## **FIRE RISK MANAGEMENT, INC.**

# **Memo Report**

**From:** W. Mark Cummings, P.E.  
**To:** Mr. Bill Hopkins; Archetype Architects  
**Subject:** **Fire Protection & Life Safety Review of the Proposed Maine Wharf Museum**

This initial review focused primarily on the proposed renovations for the 2<sup>nd</sup> and 3<sup>rd</sup> floor levels and their potential use as a museum; and specifically evaluating the available means of egress from these upper floors. The primary codes being referenced are NFPA 101 and the IBC/MUBEC. This review was based on the drawings provided by Archetype Architects; dated 05/13/2015.

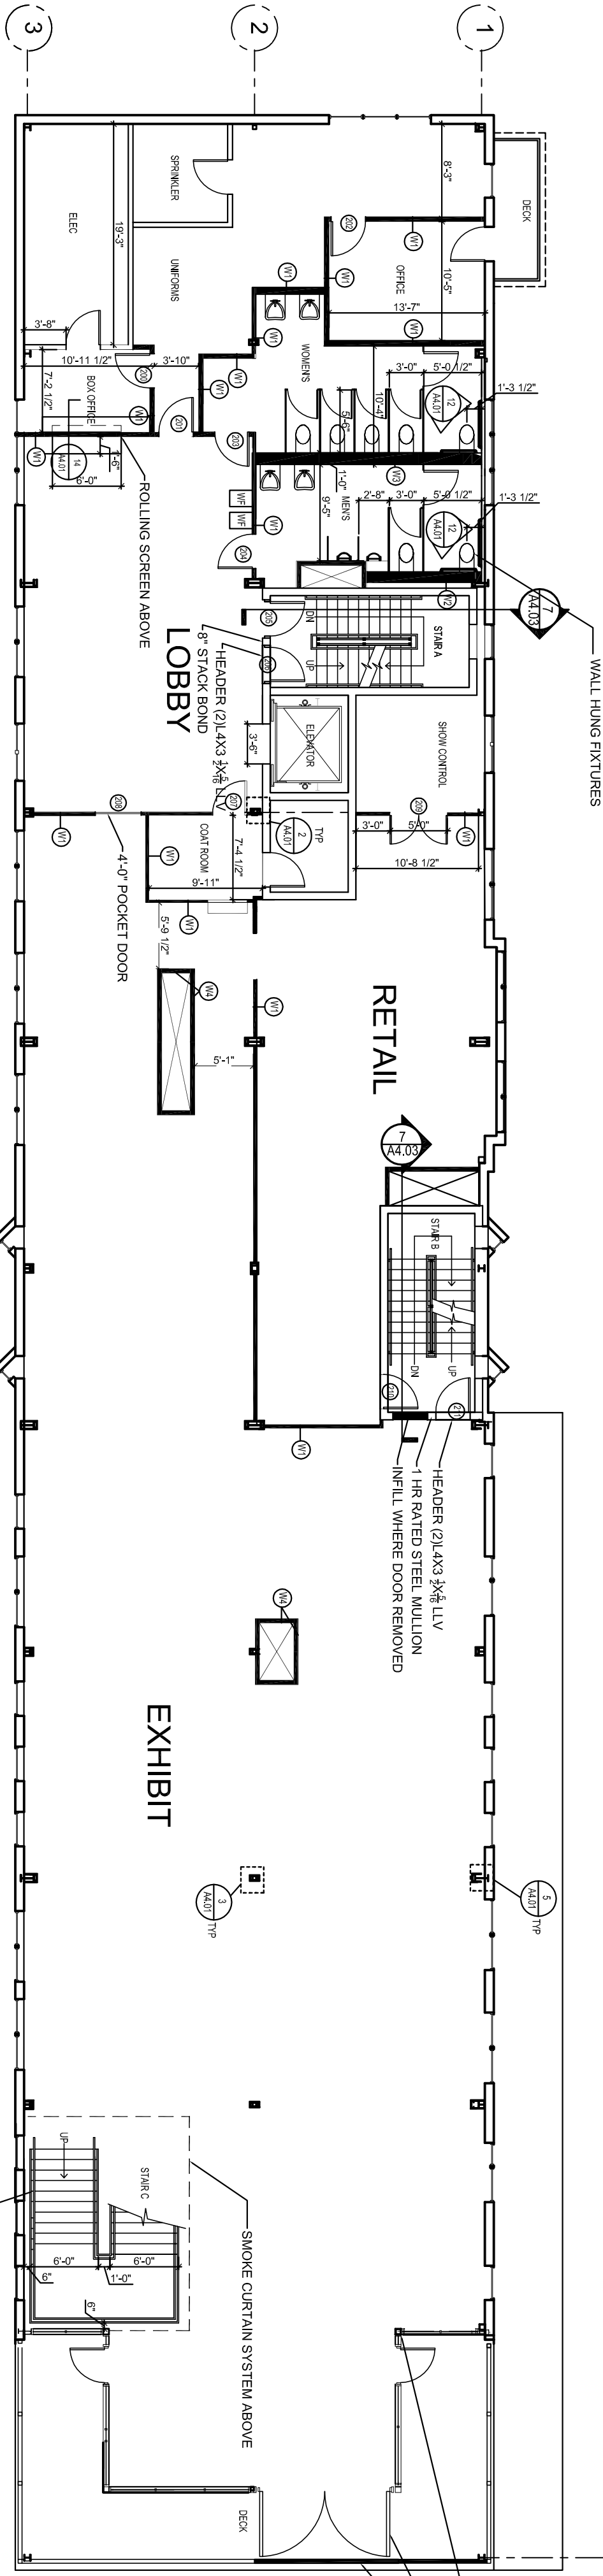
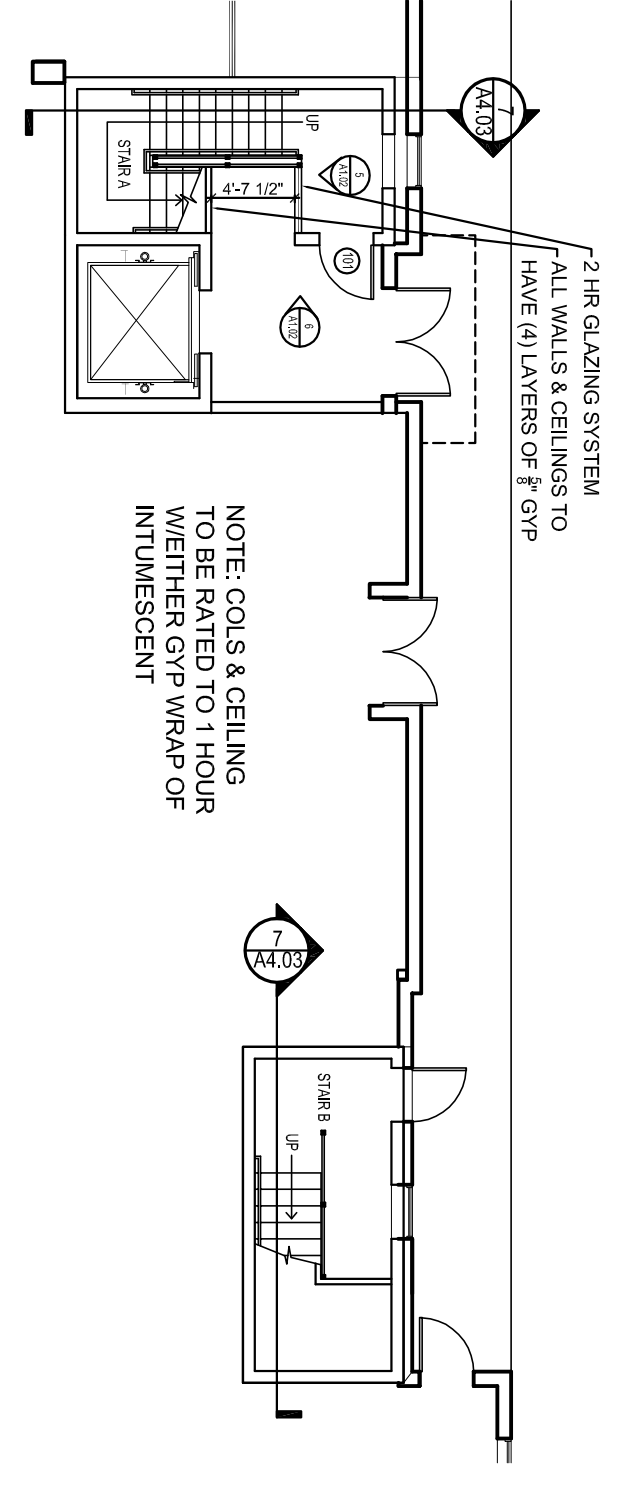
The building is provided with two stair enclosures; one of which leads directly to the building's exterior. Unfortunately, due to the location of the stair enclosures, coupled with the assembly use of the 2<sup>nd</sup> and 3<sup>rd</sup> floors, the upper floors will not meet code requirements pertaining to "common path of travel."

Specifically, the common path of travel distance from the southeast end of each floor will exceed that which is allowed by NFPA 101. Although a new stair is to be included near the southeast corner of the building, this stair only connects the 2<sup>nd</sup> and 3<sup>rd</sup> floor levels and is currently designed as being “open;” effectively meeting the NFPA definition of a “convenience opening” (stair), per section 8.6.8 of NFPA 101. Such openings/stairs are not permitted to be used as part of any required means of egress.

If this stair can be used as part of the required means of egress, it would allow occupants within the southeast end of the building that may be isolated from accessing the center stair enclosure (Stair B) by a fire on their particular floor to then move to the alternate floor level to gain access to the stair enclosure. Even when using this more “circuitous” route, the total travel distance to an exit is still within the 250-foot maximum allowed by NFPA 101.

Based on the initial review of the plans provided for the proposed renovations to the 2<sup>nd</sup> and 3<sup>rd</sup> floors of the Maine Wharf building, it will be necessary to take steps to alleviate the excessive length of the common path of travel distance from the southeast end of the building. Without making major structural changes to the building itself, beyond that which is already planned, the most viable option to correct this code deficiency appears to be providing separation for the stairway connecting the 2<sup>nd</sup> and 3<sup>rd</sup> floor levels in this area of the building. Based on discussions regarding the Tenant’s requirements for the museum, it is recommended that consideration be given to separating this stairway from the remainder of the building, using an alternative approach that is designed to provide an equivalent level of protection to that which would be afforded if “standard” fire rated assemblies were used. It is believed this can be achieved through the use of glass, or partial glass, walls and doors that are specifically protected using the installed fire sprinkler system. Equally, automatic closing doors controlled by the fire alarm system could also be used to allow the uninterrupted flow along these stairs during normal operations. However, any such approach will need to be approved by the AHJ(s); and such approval should be obtained prior to moving forward with any efforts along these lines to ensure they are, in fact, willing to consider a performance-based alternative.
